7 August 2015
Ref 15028

**PROPOSED MIXED USE DEVELOPMENT
23-41 LINDFIELD AVENUE, LINDFIELD
TRAFFIC AND PARKING MATTERS**

I refer to Council's submission dated 29 May 2015 concerning the abovementioned development proposal. The following advice is provided in response to the car parking-related matters raised on page 13 of the Council's submission.

Drawing Title
BASEMENT 2 PLAN

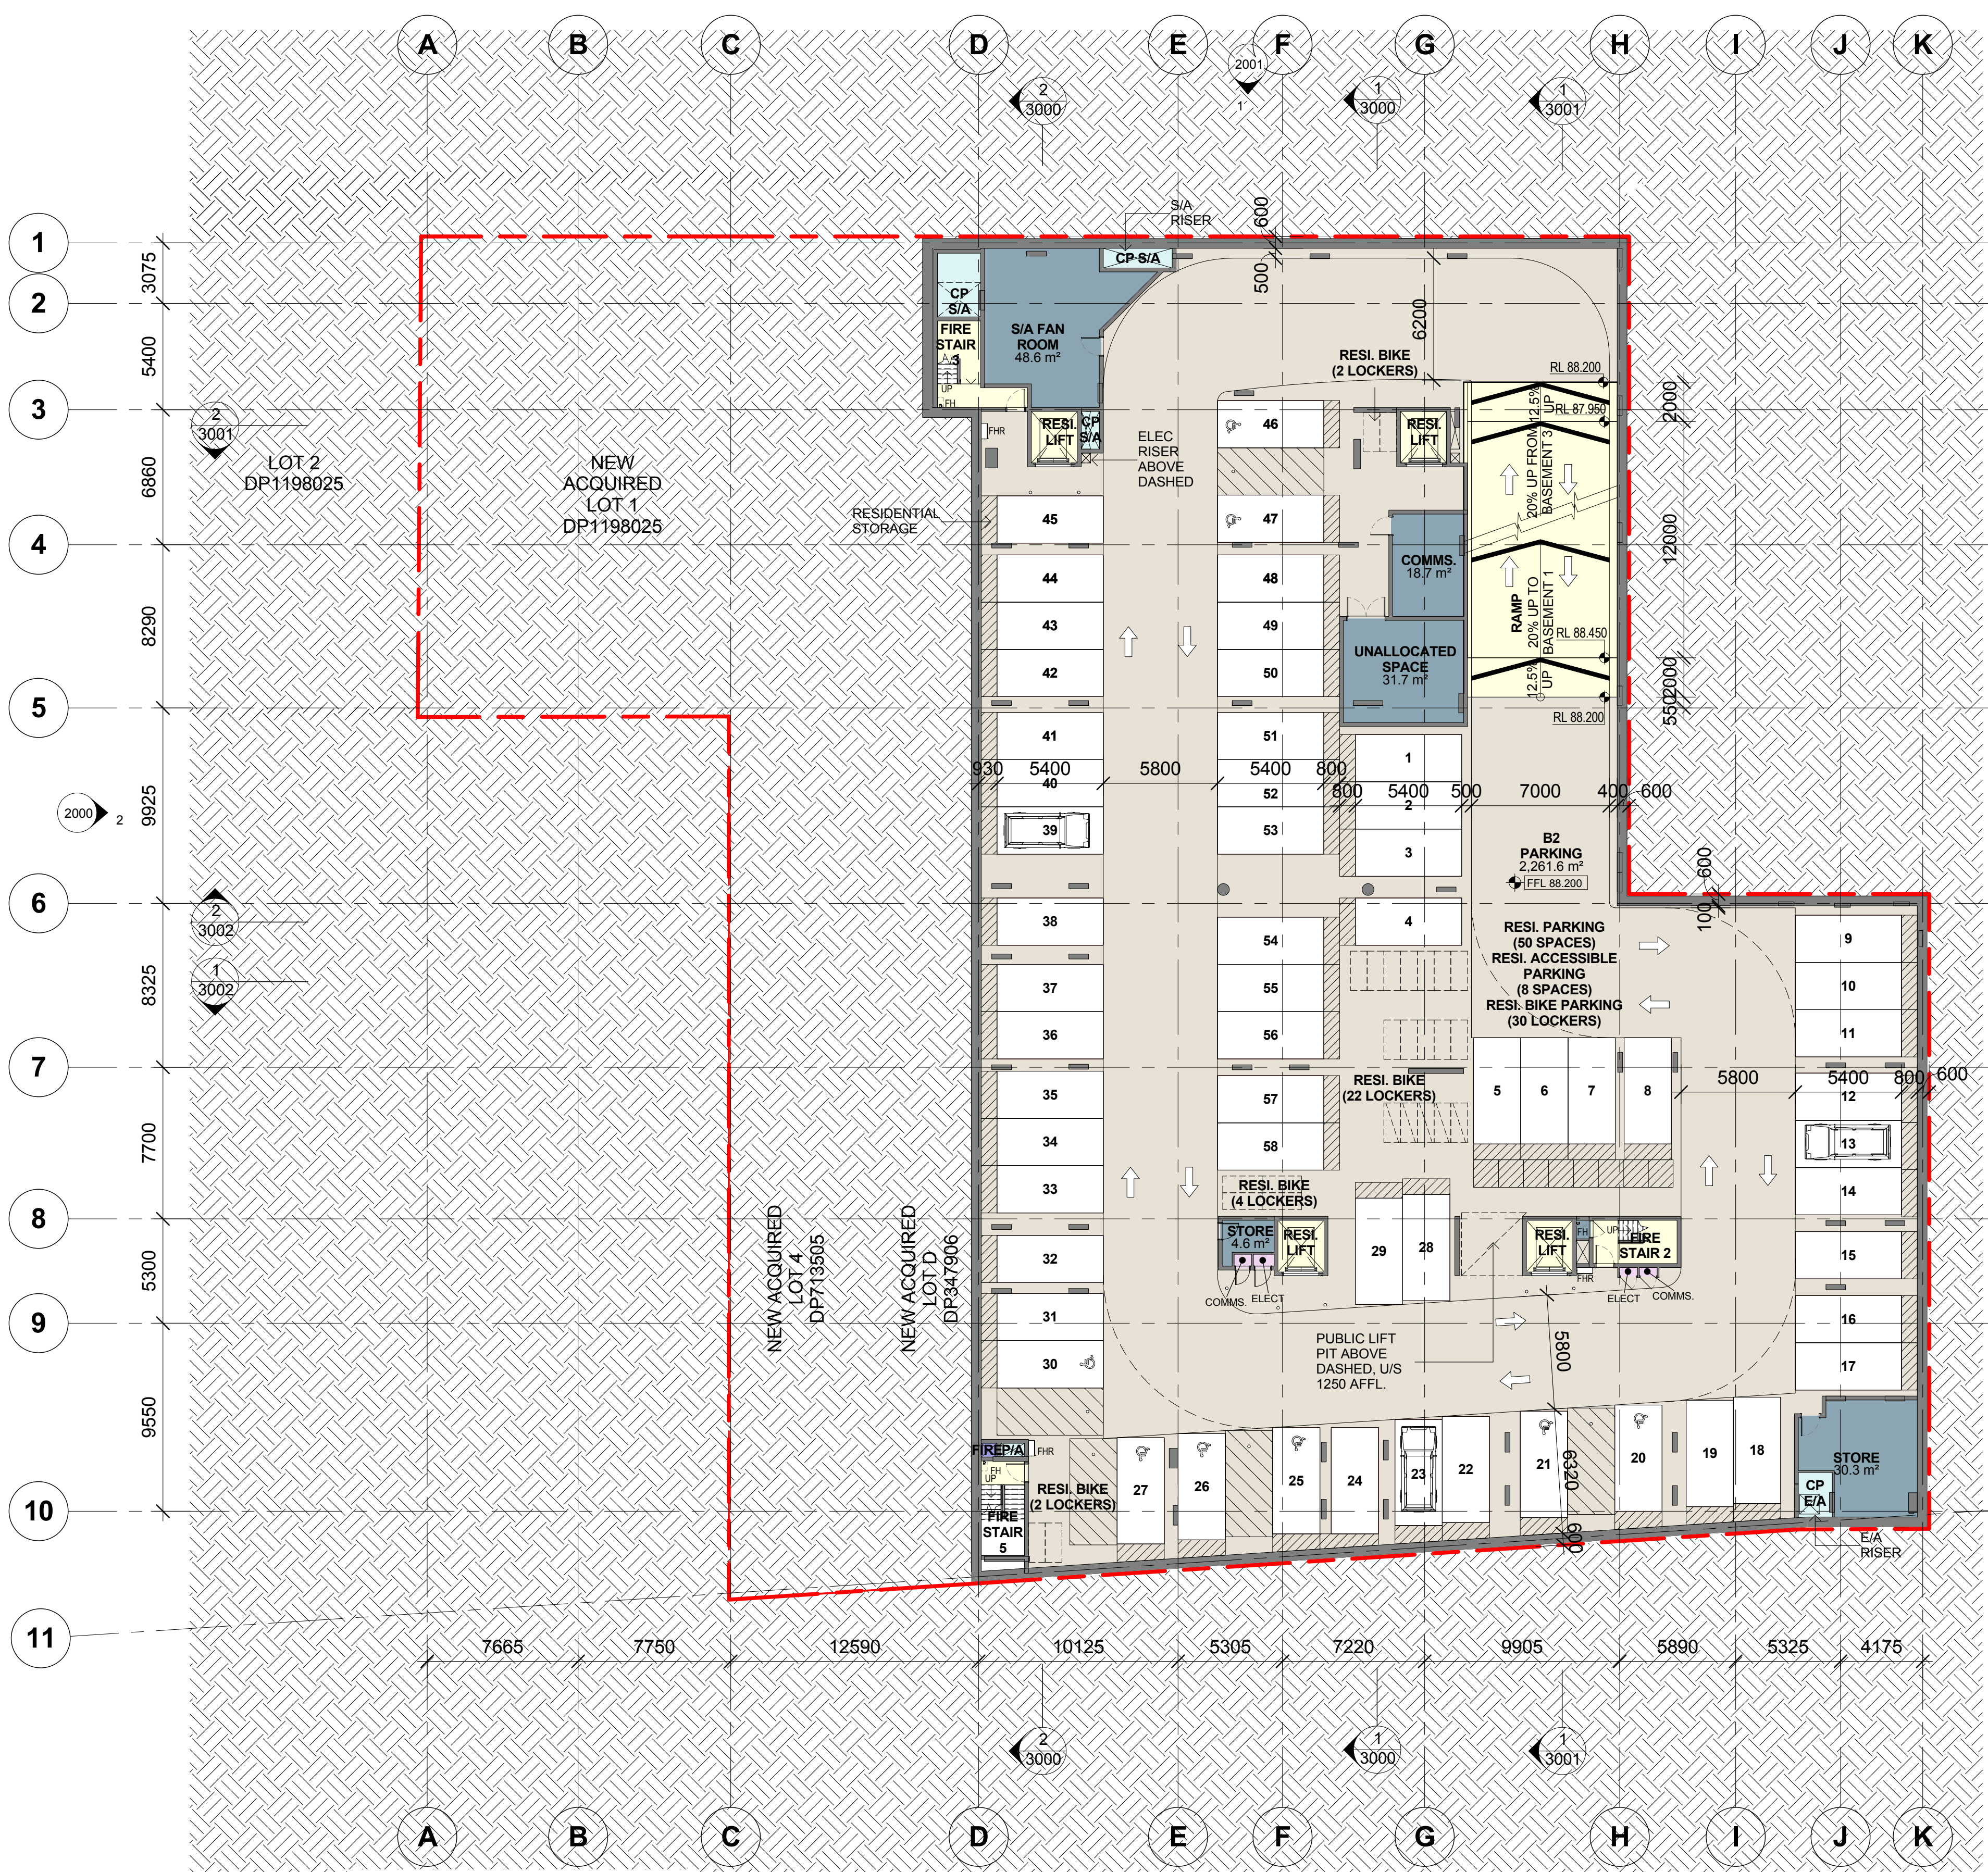
Council's reference to *Clause 2.5.2(c) of AS2890.1 - 2004* seems to be suggesting that provision should be made for two large vehicles to pass each other at ramp junctions whilst travelling in opposite directions.

However, the ramp width and aisle width dimensions provided at grid reference F2 on Basement 1 and a grid reference F2 on Basement Levels 1 & 2 are consistent with the dimensions provided on the previously approved MOD1 & MOD2 plans.

Those dimensions also comply with (and exceed) the ramp width and aisle width dimensions specified in *AS2890.1 - 2004*.

In the circumstances, it is considered that the previously approved ramp width and aisle width dimensions should be retained unchanged.
